A1 Birtley to Coal House

Scheme Number TR010031

7.6 Statement of Common Ground: Historic England

STATEMENT OF COMMON GROUND: HISTORIC ENGLAND

**Longbank Underpass**  
**PLAN**  
 SCALE 1:200

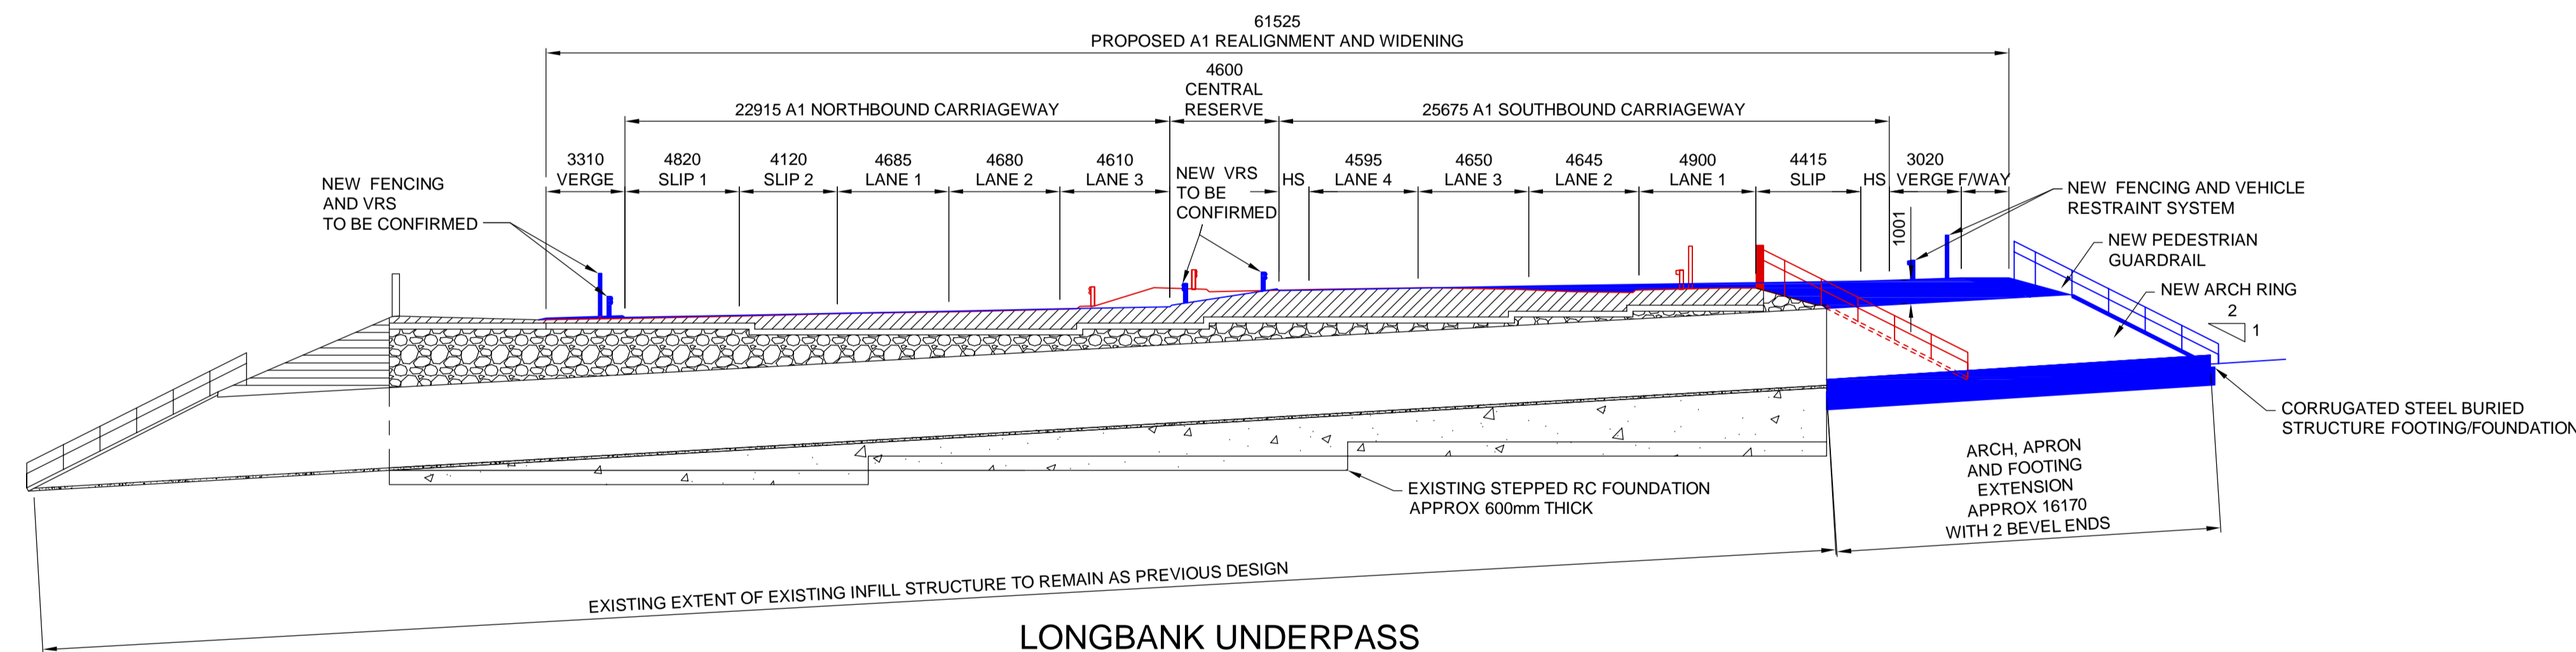
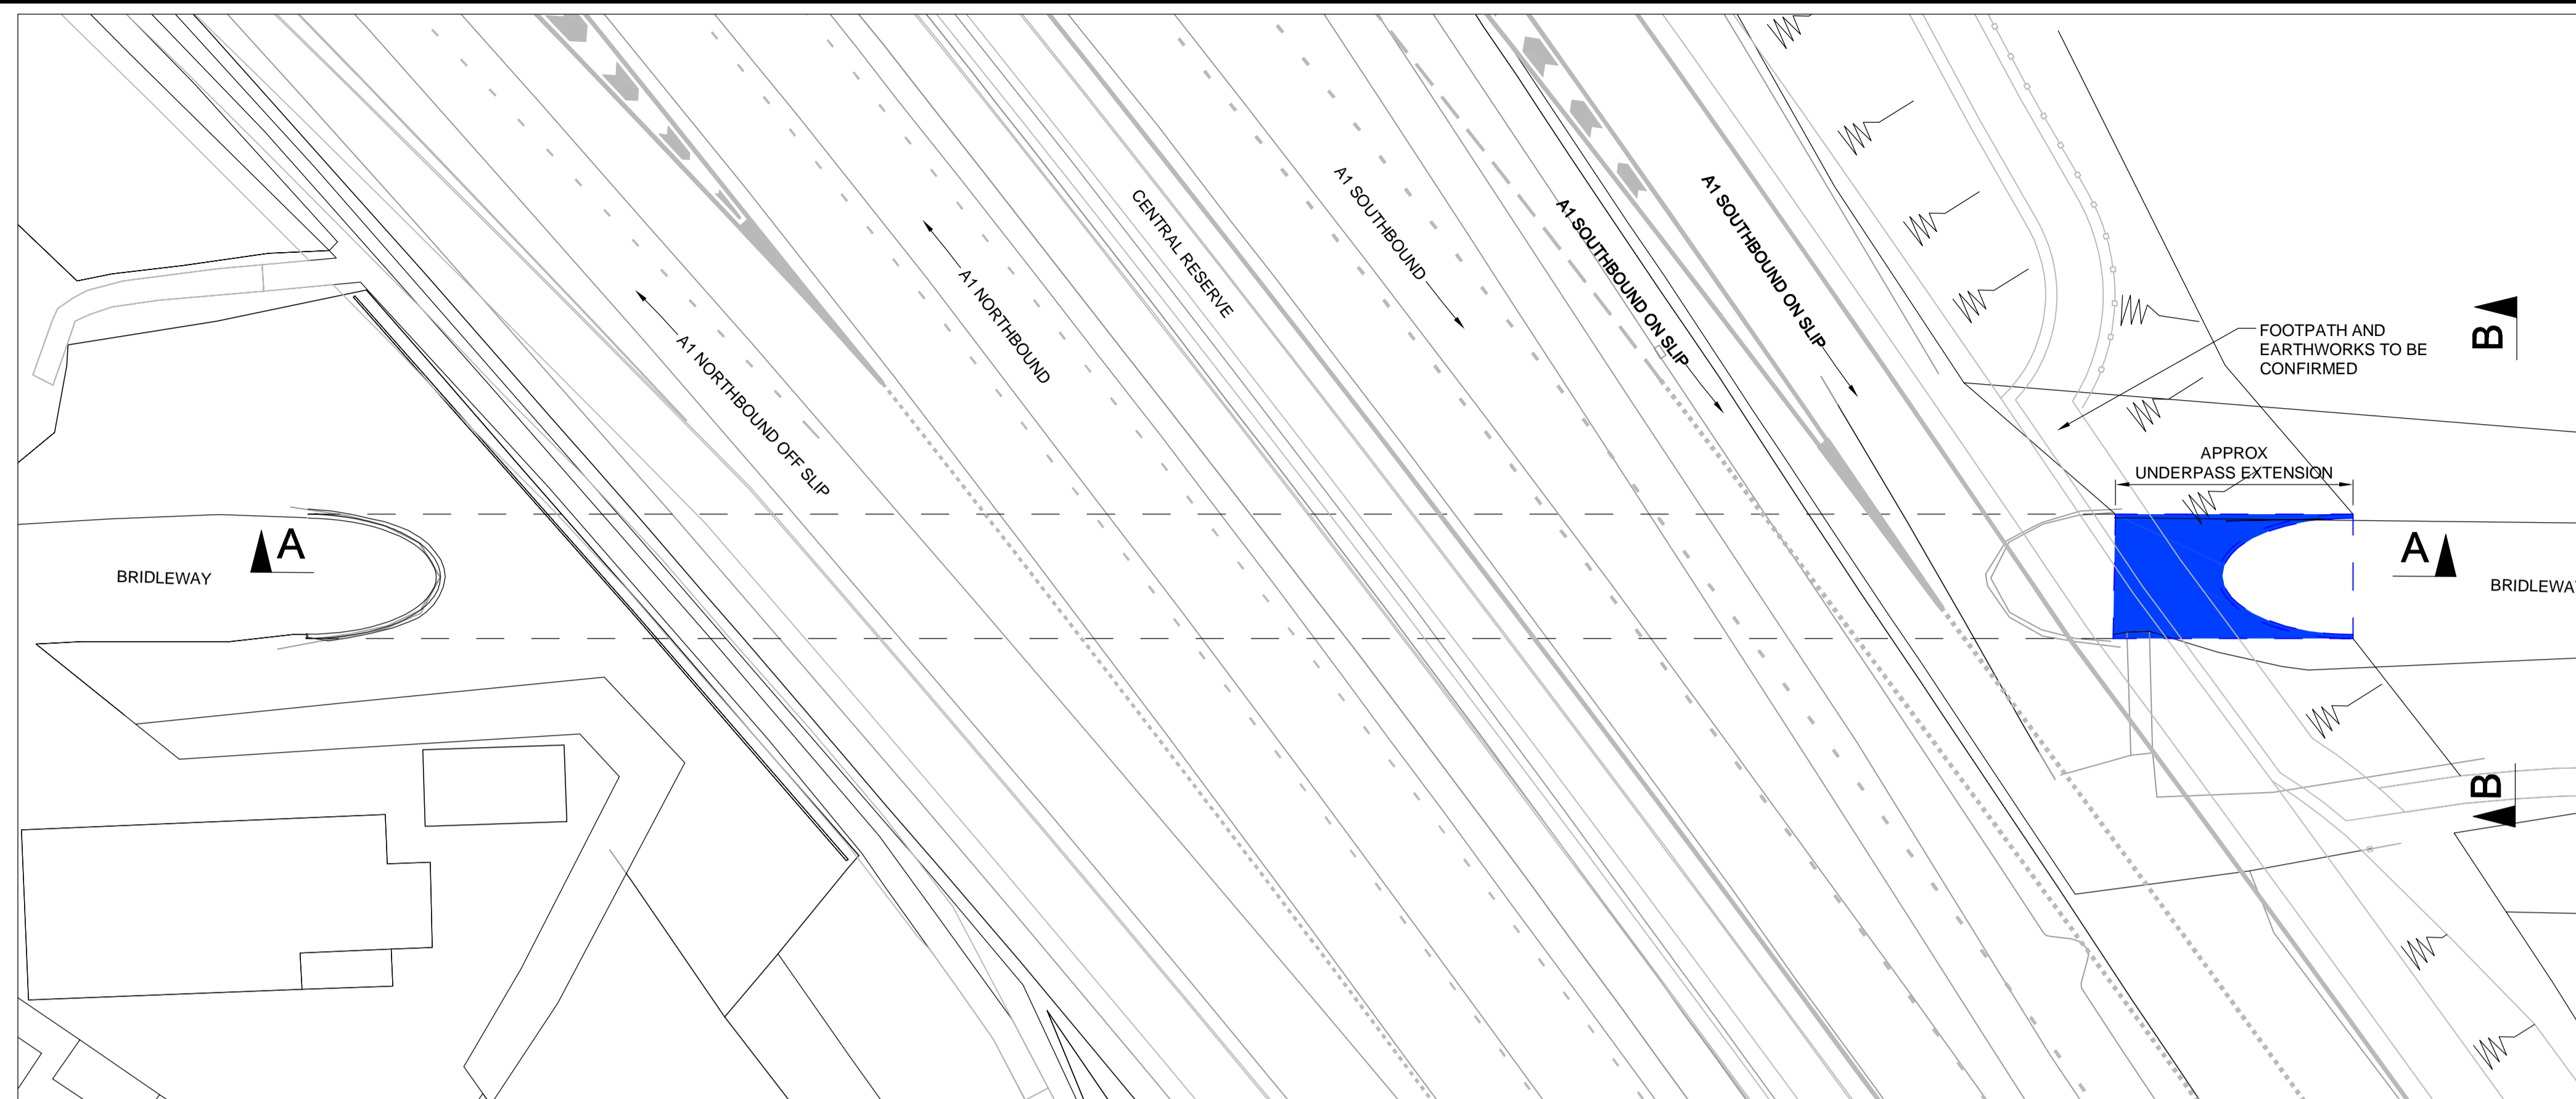
3	<p>Longbank Underpass Extension</p> <p>█ talked through the engineering aspects of the underpass extension with the proposed structural form to be on a like for like basis. This shall constitute:</p> <ul style="list-style-type: none"> • Extension of the existing underpass by a total length of approximately 16.1m to the northern entrance of the structure. No works are proposed to the southern entrance of the structure, • Structural form of the proposed superstructure shall be similar to existing i.e. Corrugated Steel Buried Structure (CSBS) with a profiled reinforced concrete collar and earthwork batter to tie into the existing structure. The substructure shall be reinforced concrete pilecaps founded on bored piles, • A high level construction sequence of the proposed structure shall comprise: <ul style="list-style-type: none"> a) Set up pedestrian/equestrian diversions b) Installation of protection to the existing path (i.e. road plates, timber boards etc.) to avoid damage to the path/surfacing during construction works c) Removal of existing masonry walls abutting the northern entrance of the underpass d) Bench back existing embankment e) Excavation of trenches either side along the edge of the path for the new foundations f) Installation of bored piles, concrete pilecaps and upstand g) Installation of new CSBS arch including removal of existing concrete collar and stitching to existing arch h) Installation of new concrete collar 	-	-

<p>i) Backfill structure and install guardrail</p> <p>j) Reinstate remaining masonry walls up to the new underpass extension in a similar fashion to existing</p> <p>k) Install access steps down embankment</p> <p>There are no plans to disturb the path and/or surfacing during the underpass extension. Though protection measures will be in place, any damage to the path as a result of construction activity shall be rectified. It was also recommended in the structure options report that all outstanding maintenance actions recorded in the previous inspection reports be completed as part of the extension works.</p> <p>█ stated an initial contractor review determined that the existing Longbank Underpass will remain closed during the construction works. As a mitigation measure, there are preliminary provisions for a diversionary route for pedestrians/equestrians along Eighton Lodge junction.</p> <p>Access provisions for construction personnel/vehicles are anticipated to be via an existing path to the north-west of the existing underpass structure.</p> <p>Further details of the above are expected to be reviewed and clarified at detailed design stage.</p>

<p>5</p>	<p>Historic England Recommendations</p> <p>In principle, there were no objections to any of the current designer proposals for the underpass. In addition, █ recommended the following be carried out:</p> <p>Investigations to be undertaken by the Cultural Heritage team as part of ES ;</p> <ul style="list-style-type: none"> • A walkover survey to be conducted by along the section of monument that requires consent. The aim of the survey will be to identify any features/ structures associated with the railway that are presently hidden by vegetation and to assess the condition of the scheduled retaining wall. Vegetation to be cleared from lower half of the embankment prior to the survey taking place to enable observations. • To produce, through rectified photography, an elevation and plan of that section of retaining wall that is proposed for demolition in addition 	<p>-</p>	<p>-</p>

<p>to the recording of any features/structures identified in the walkover survey.</p> <p>If Scheduled Monument Consent is granted, the following recommendations for mitigation have been made;</p> <ul style="list-style-type: none"> • The dismantling of any part of the scheduled retaining wall should be undertaken by an archaeologist, prior to the commencement of evaluation trenching. • Evaluation trenching should be undertaken pre-construction at the location of the proposed foundation trench for the new underpass sleeve. • To offset the harm to the scheduled retaining wall and to enhance the appearance of the SM, a section of surviving wall of equal length to that being demolished should be repaired, if found to be in a state of disrepair during the walkover survey. <p>Matters to discuss with GCC planning archaeologist;</p> <ul style="list-style-type: none"> • The requirement for archaeological monitoring of any works that may require disturbance to the railway embankments. Such works may include the instalment of a new public access staircase and a bridleway.
